7 July 2026

CMRI Gene Technologies Building (SSD-45576956) – Preliminary Issue

Subject: Response to Request for Additional Information

Figure 2: Access Arrangement

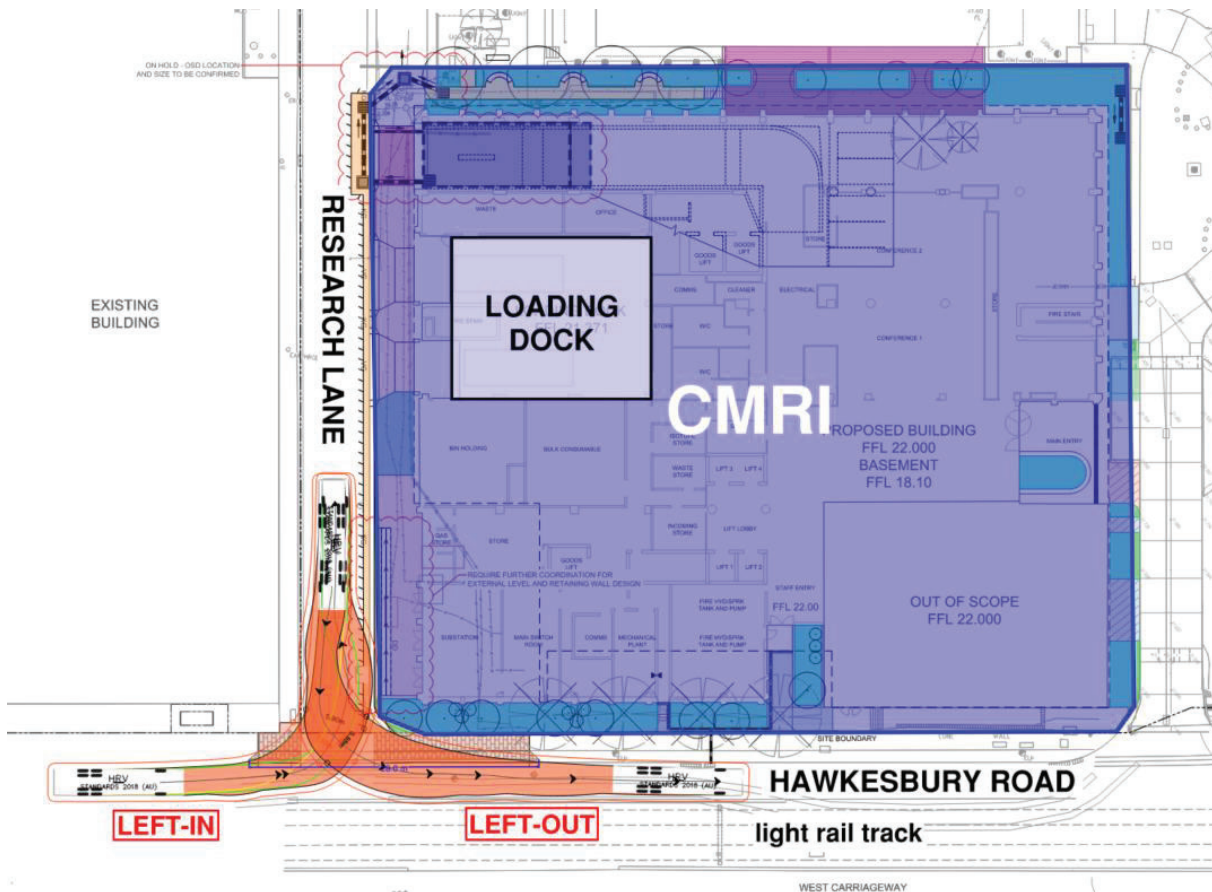
TfNSW have requested, Prior to the Issue of the Occupation Certificate, driveway/access to Research Lane is designed to ensure heavy vehicles are able to enter and exit without traversing over the PLR line and without mounting the kerb. DPHI highlighted these proposed conditions of consent for the applicant's particular attention.

Request: DPHI requires additional information to assess the operational impacts of Heavy Rigid Vehicle (HRV) entering and exiting the development site. The information submitted must clearly detail why HRVs need to be able to access the site (rather than Medium Rigid Vehicles), the frequency of visits and how these arrivals and departures will be safely managed.

Response: A Preliminary Site Access Management Plan has been prepared by TTW to provide the requested details regarding heavy vehicle frequencies, access routes and management practices and is provided at **Attachment C** to this letter.

DA_LA_2112

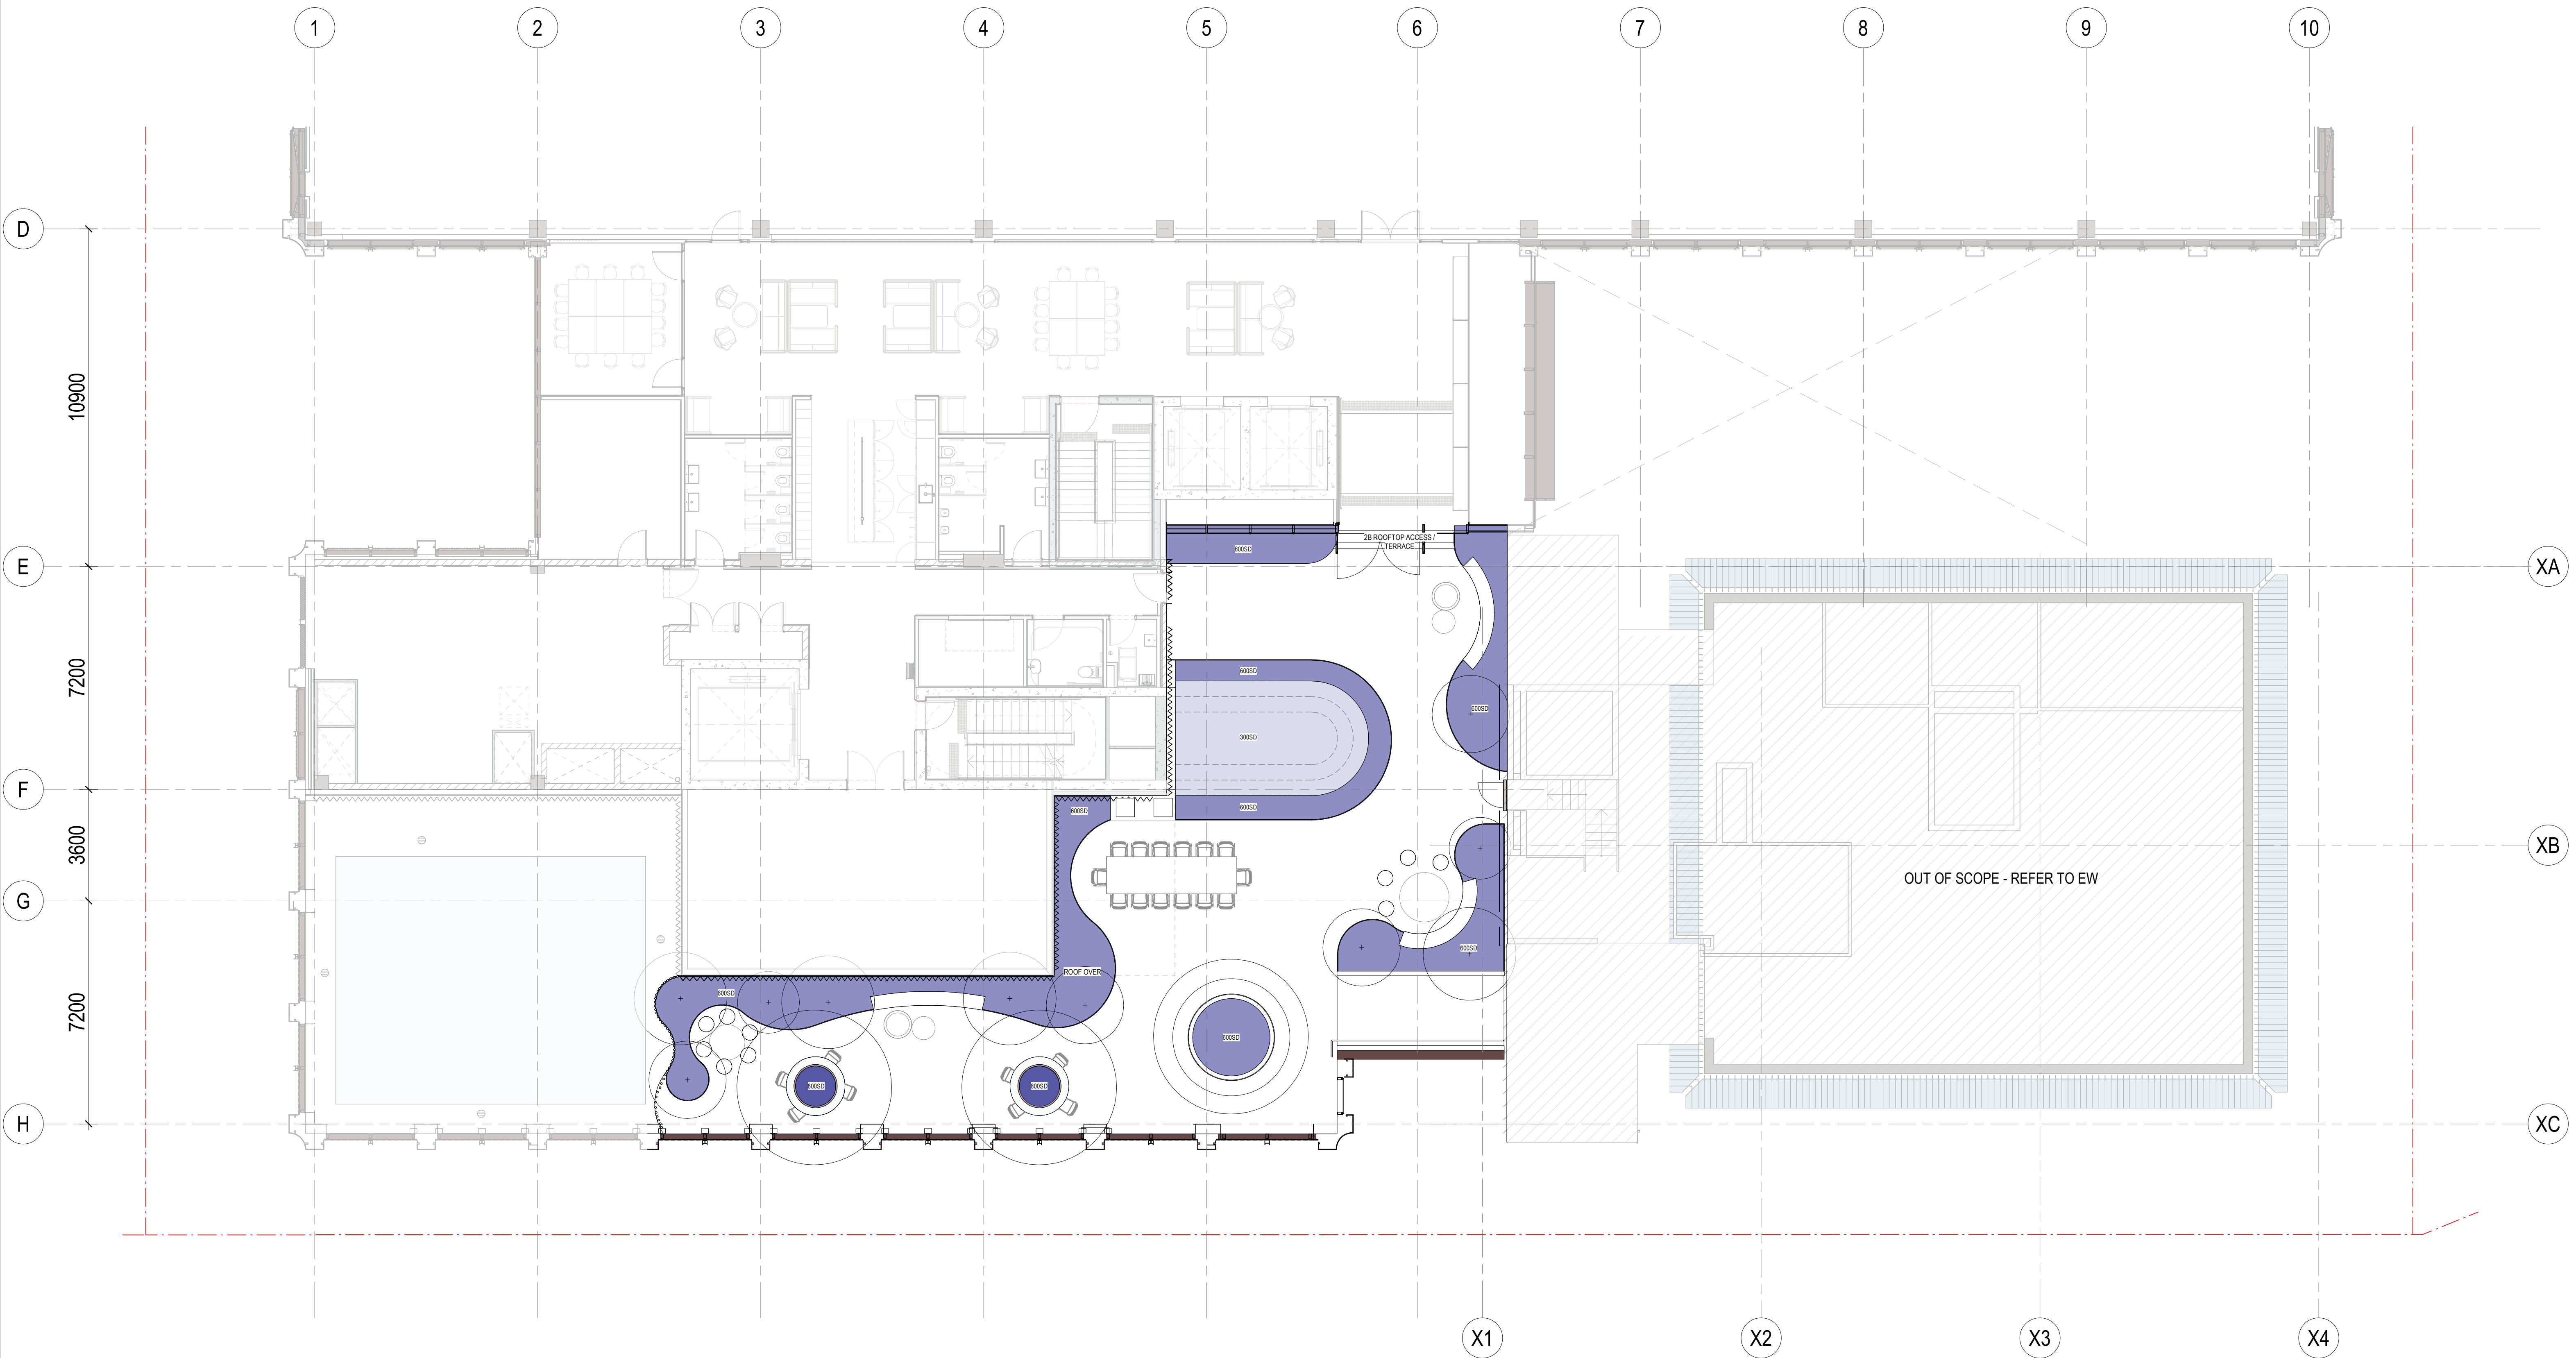
Request: Council advises that, overall, the proposed landscape plans are supported. However, Council has queried the adequacy of certain deep soil volumes to support the long-term health of the proposed planting, as well as potential conflicts between tree roots and canopy with above- and below-ground infrastructure. Council has also requested clarification of certain colour coding shown on the submitted Landscape Plans.

Response: Hassell have received the proposed soil depths and associated planting with consideration of expert arborist advice. In summary:

- 800mm soil depth is sufficient for small trees.
- 600mm soil depth is not sufficient for small trees and these areas have now been increased 700mm+ to support the proposed planting.
- 200mm soil depth is commonly accepted for mass planting on green roofs and will utilise high inorganic matter growth media.
- *Angophora floribunda* have been replaced with *Acmena smithii* 'Sublime' to better suit the proposed conditions.
- *Eucalypts fibrosa* will be replaced with *Tristaniopsis laurina* and *Cupaniopsis anacardiopsis* to better suit the proposed conditions.
- There is not sufficient room to offset trees on Ambulance Drive 2m from the building façade. Accordingly, these trees will be replaced with *Acmena smithii* 'Sublime' as this is a smaller species which will not clash with the building and hardscape.

Updated Landscape Plans are provided at **Attachment B** to this letter. The proposed soil depths are shown on the soil depth key on Plan DA_LA_0003 and the corresponding soil depths shown on Plan DA_LA_2101, DA_LA_2112 and DA_LA_2171.
